## **KELLYVILLE AND BELLA VISTA STATION PRECINCT**

### **Landscape Master Plan and Open Space Strategy - Response to Submissions**

**S18-0057**

Issue H • 17/06/2020

Figure 42: Proposed section through the Perimeter Road along the riparian corridor

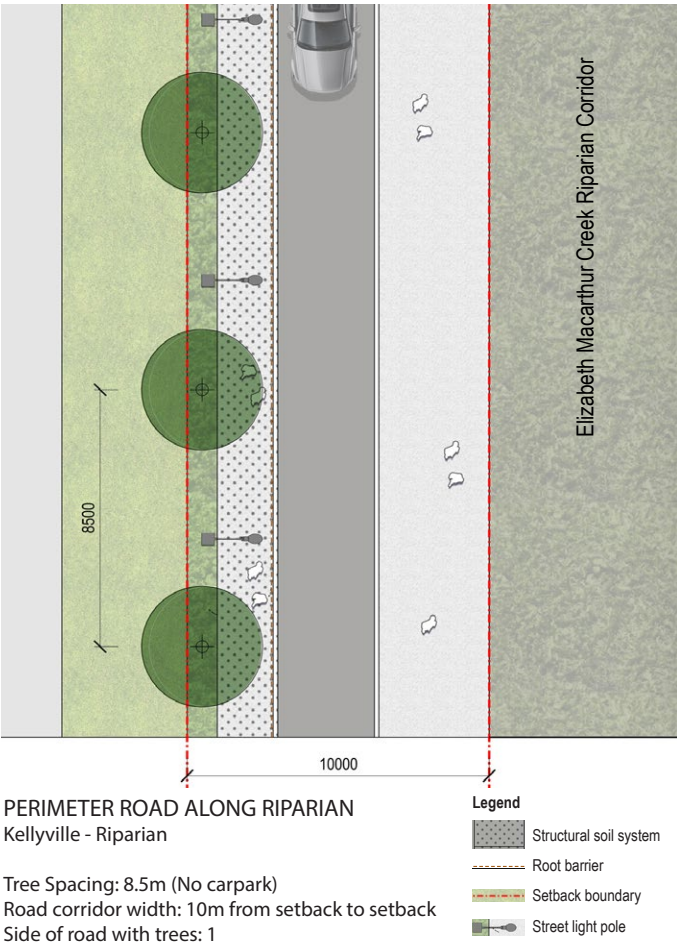
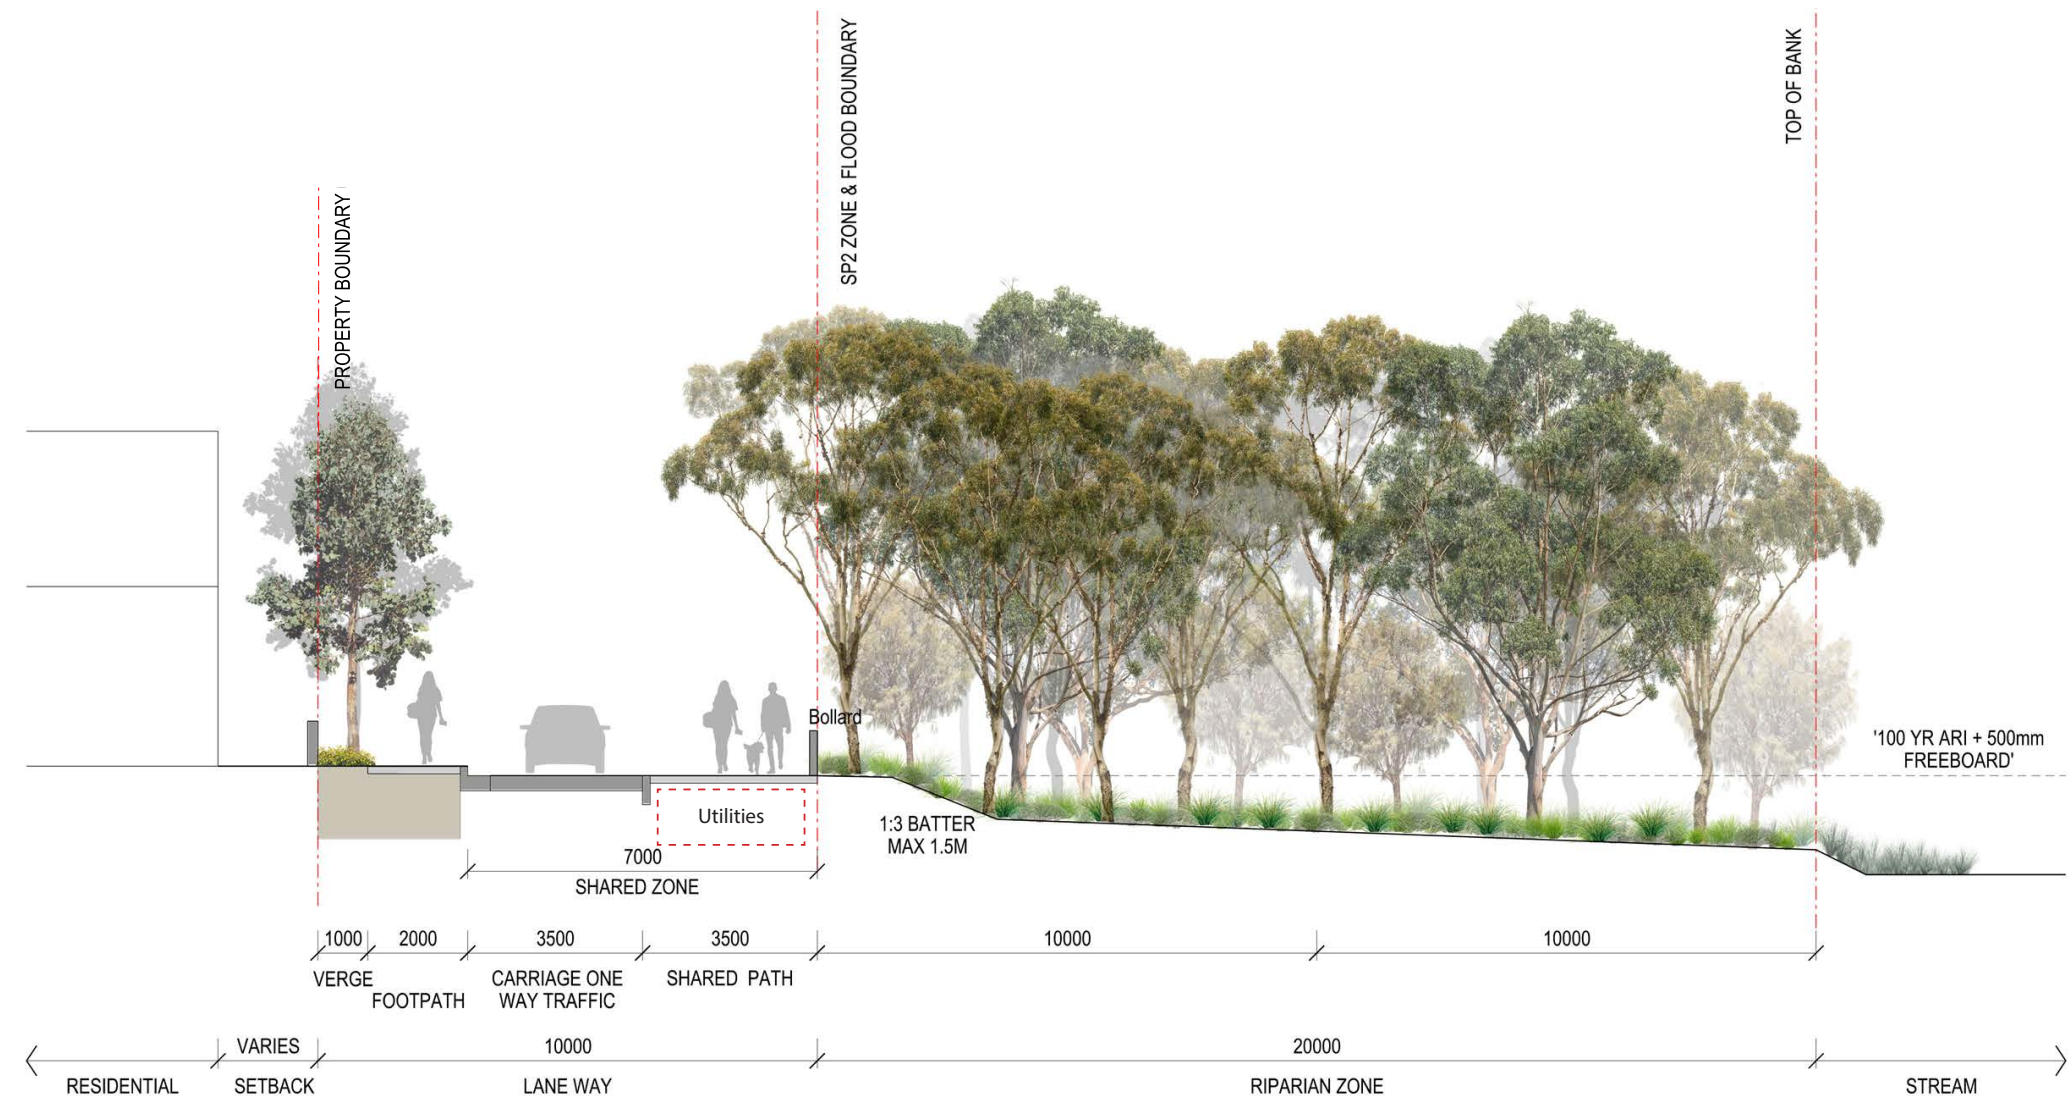
33	THSC	The provision of street trees is not considered sufficient (e.g. spacing of 15 metres). Trees should be spaced a maximum of 10 metres apart with large canopy species to support the 'Garden Shire' character and minimise environmental heat impacts.	<p>The Greater Sydney Commission has set a canopy target of 40% coverage across metropolitan Sydney (GSC Priority 16, Objective 30). The Design Guidelines have been amended to prescribe a minimum tree canopy target of 40% across both precincts. For the purposes of this project, the target of 40% canopy coverage applies to the public realm inclusive of public open space and streets. This is of particular importance in the reduction of the urban heat island effect. The document has been updated to provide details of how street tree coverage will be maximised and best practice to optimise healthy tree growth within hard-surfaced spaces. Trees of varying sizes have been selected to compliment the differing street hierarchies and in total the canopy coverage for street corridors amounts to 49.8% in Bella Vista of the total area of street corridors. Minor variations in coverage is due to differing street sizes.</p> <p>Large tree canopy species have been proposed to meet the character of the 'Garden Shire' and ensure canopy coverage.</p>	Page 10-21
